Project Name: **ACADEMY PLACE SUBD.**

SUBJECT: EPC CONDITIONS FOR PROJECT 1001993

7. Project # 1001993

DEVELOPMENT REVIEW BOARD
January 8, 2003
Project # 1001993

PLAT OF TRACTS F-1 AND Q-1, ACADEMY PLACE

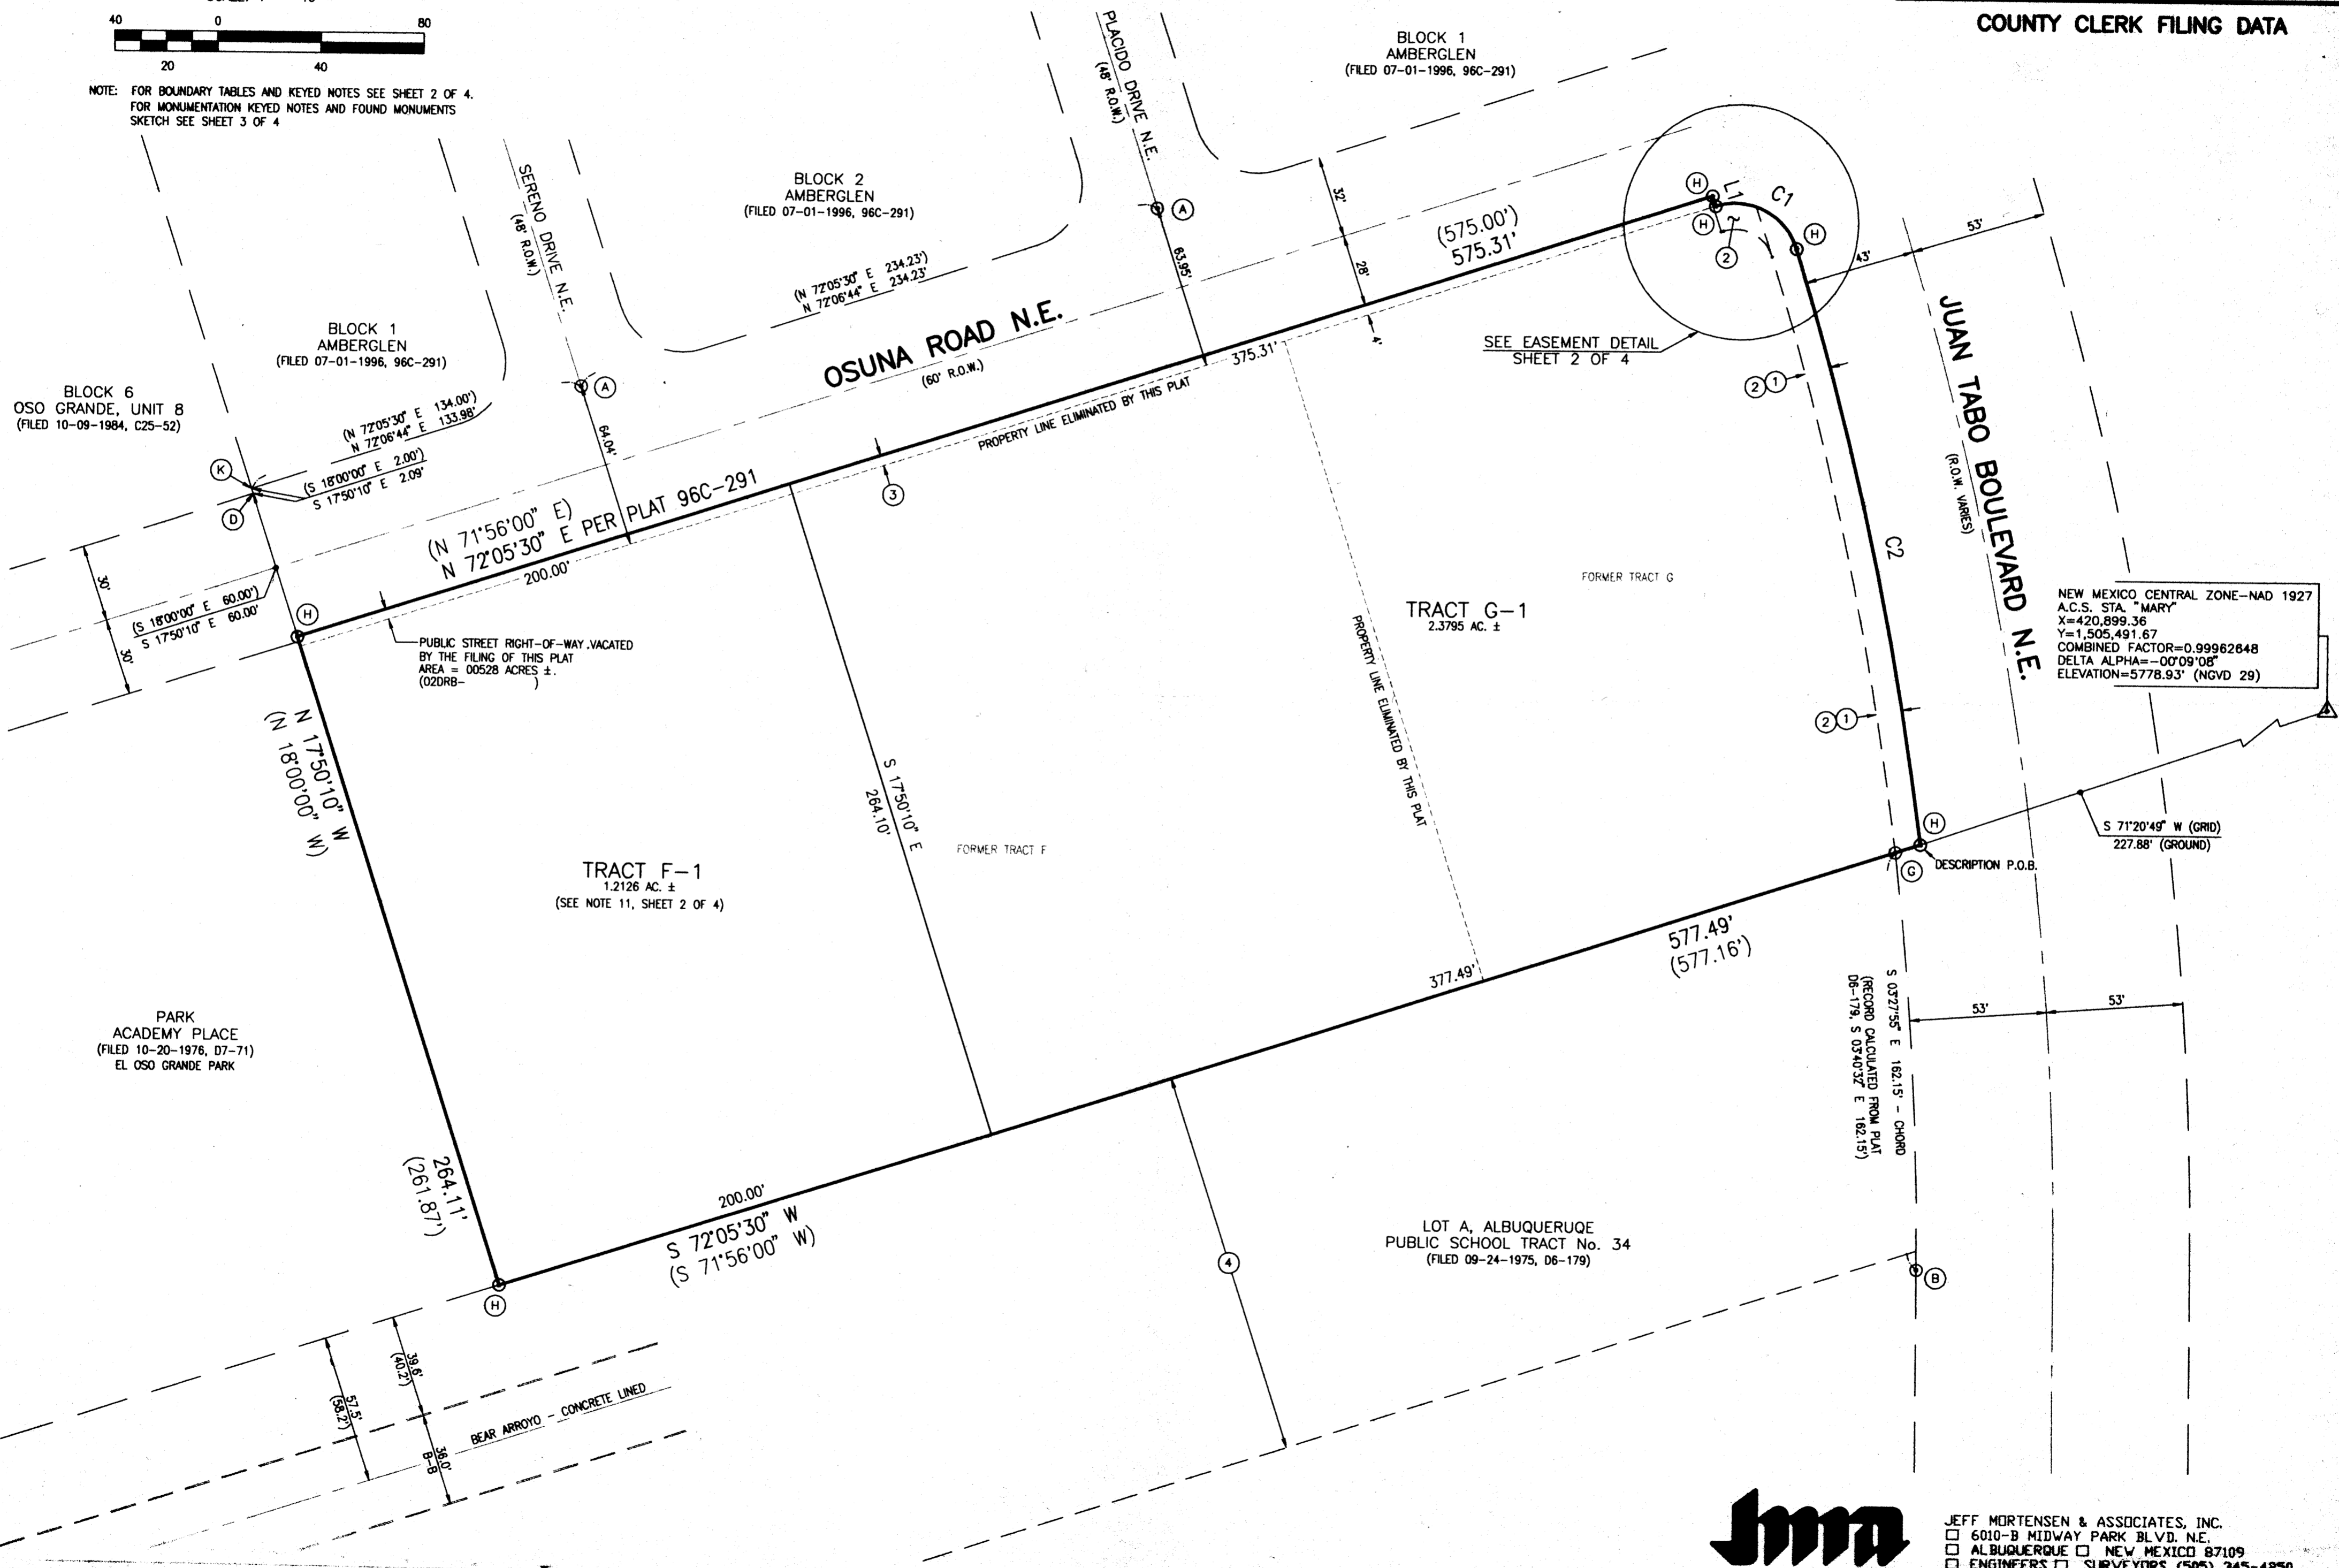
PNM Electric	Approves vacation of south 4' of Osuna Rd.
--------------	--

No objection to Vacation request. Minor questions/comments on Plat.

Real Property's signature on the plat is required prior to Planning's sign off. Planning will record the plat as it involves vacation of public right of way. Please provide a check payable to Bernalillo County for the fees, a tax certificate from the County Treasurer's office, a tax printout from the County Assessor's Office and 2 mylars.
